2008234.9/0404A/R0/TA

04/04/2012

## **Hall Street Bondi - Review of Proposed Canopy**

General Arrangement Ground Level

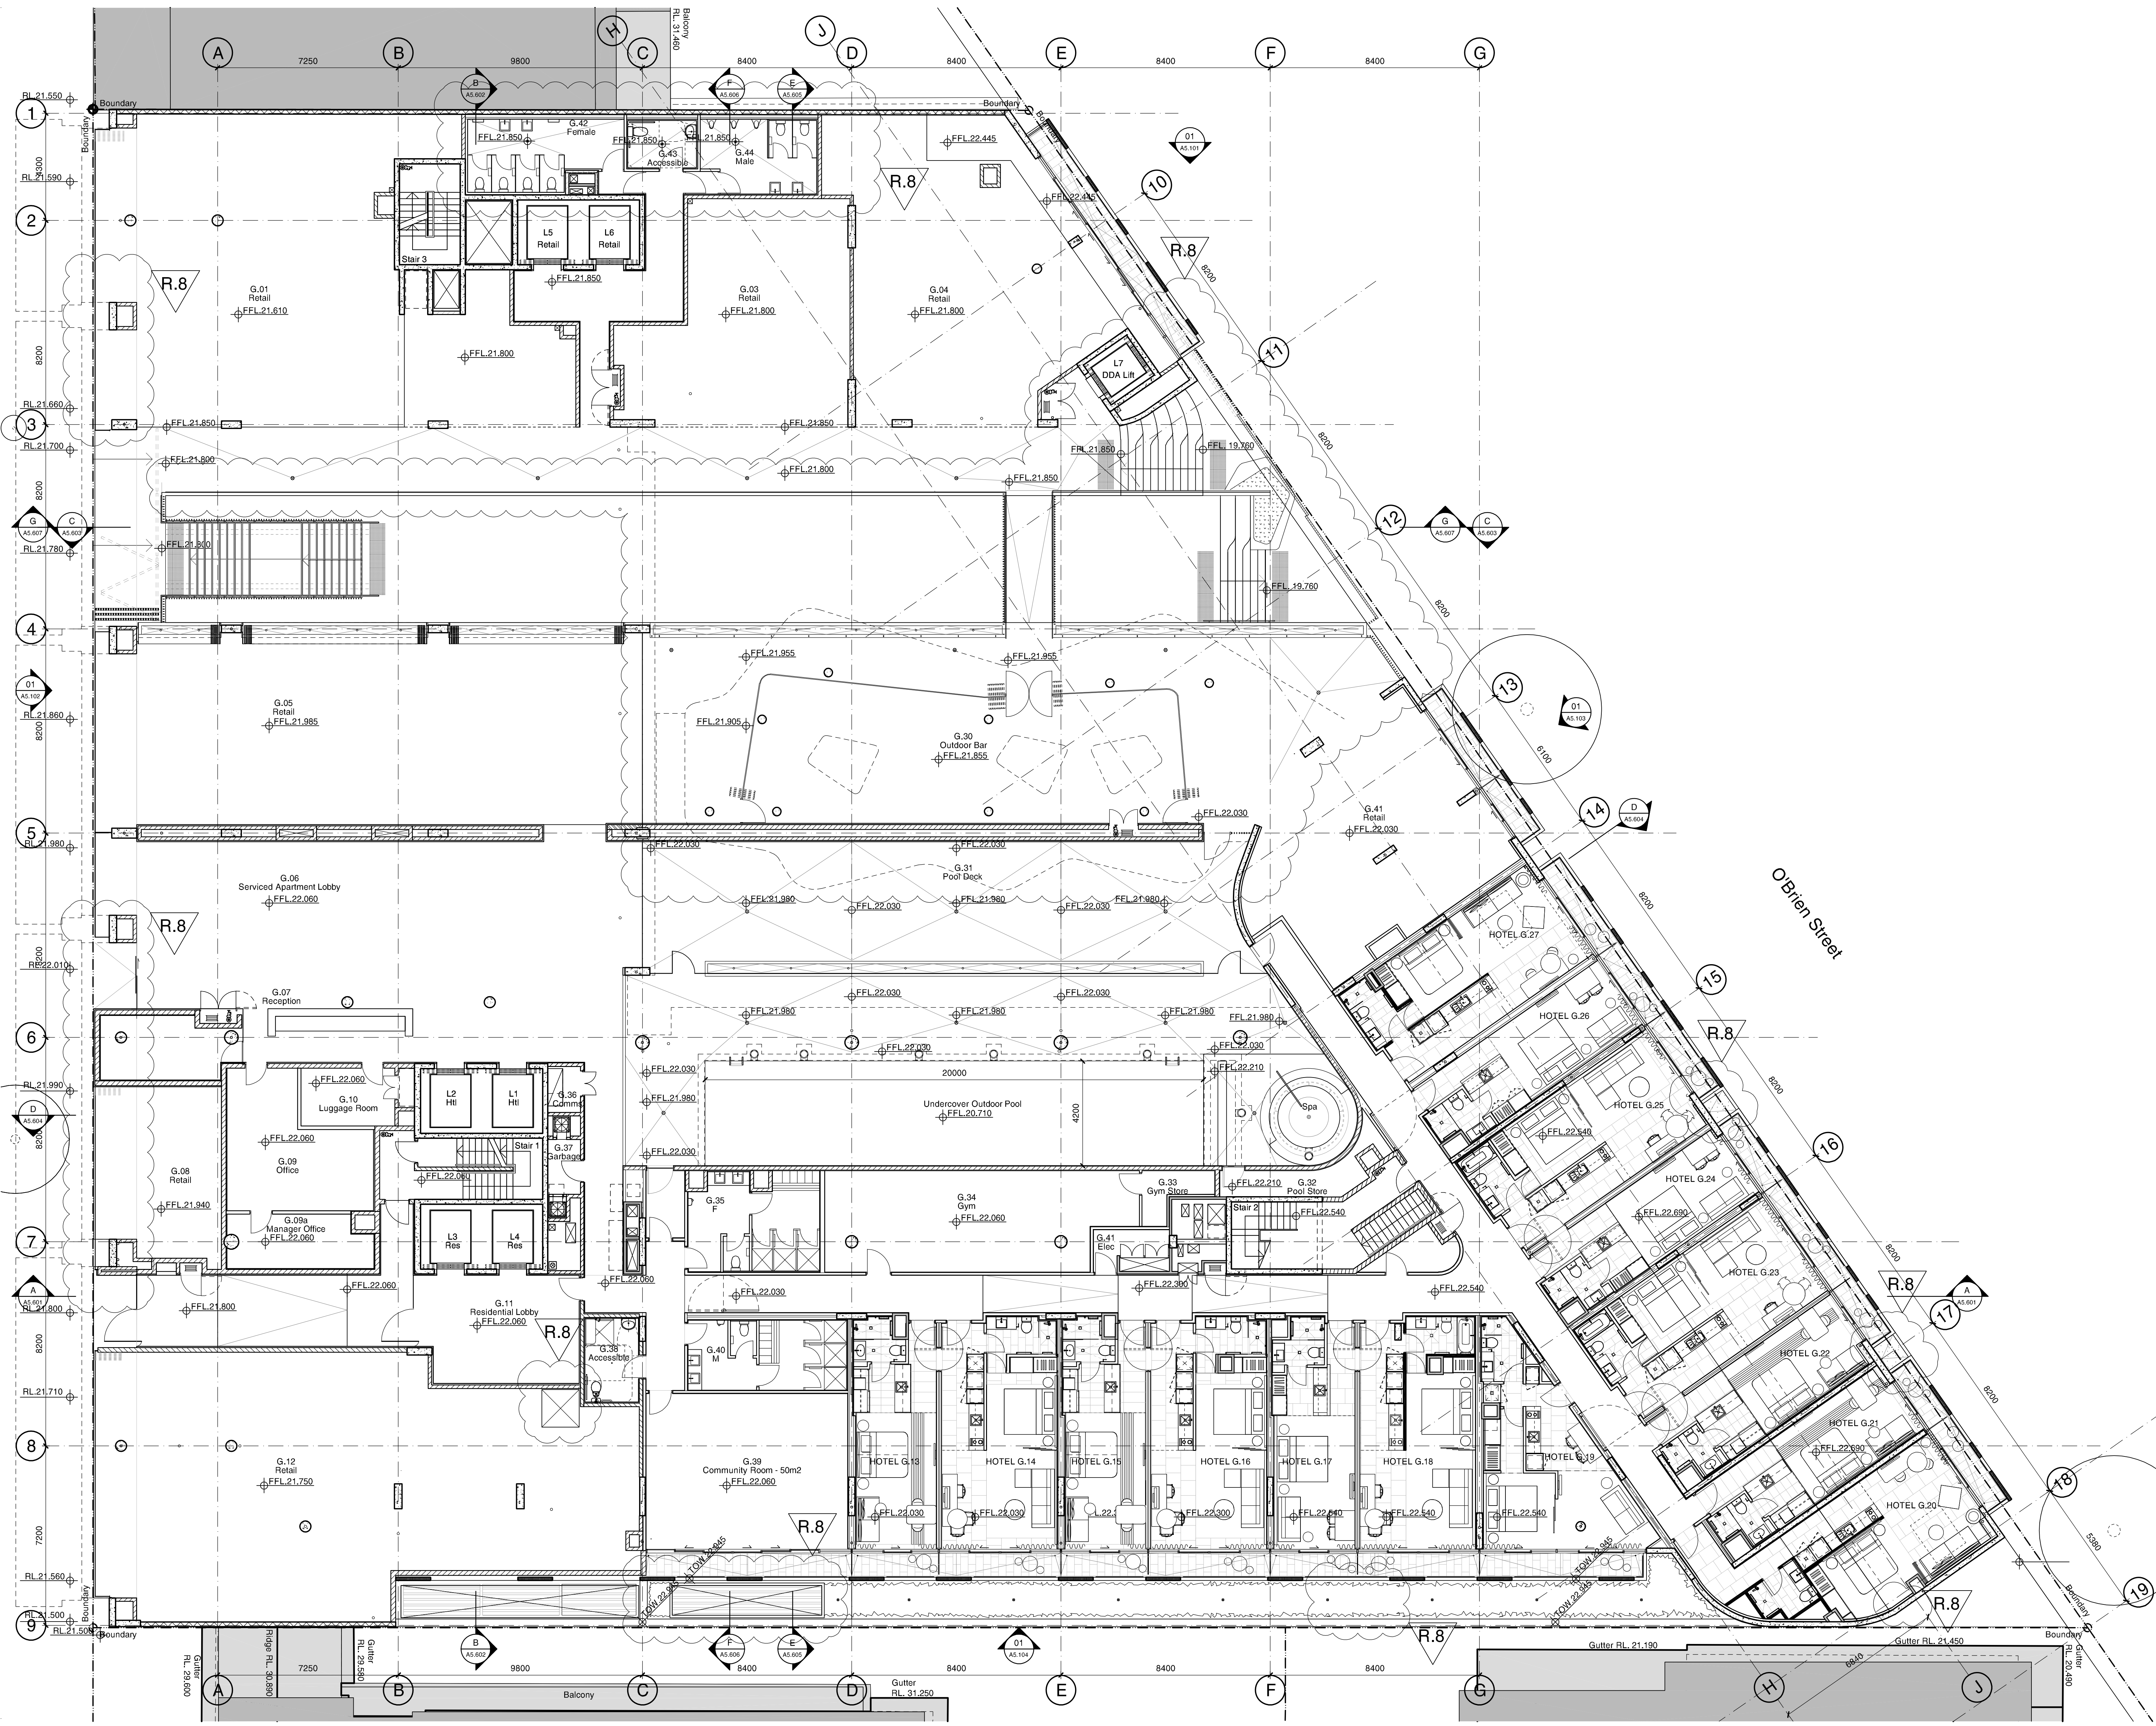
This letter presents a review of the proposed green roof canopy to be installed over the Ground Level tenancy of the Toga Group Hall Street project. It is proposed that the tenancy will be a licensed restaurant.

This letter certifies that the current green roof design and operable glass wall arrangement is consistent with the acoustic design intent of the originally specified glass canopy. In addition, due to the increased density of the green roof, the currently proposed design is marginally more effective in controlling noise breakout.

We note that recommendations regarding door seals and noise limiters should still be implemented in the design, regardless of the canopy design.
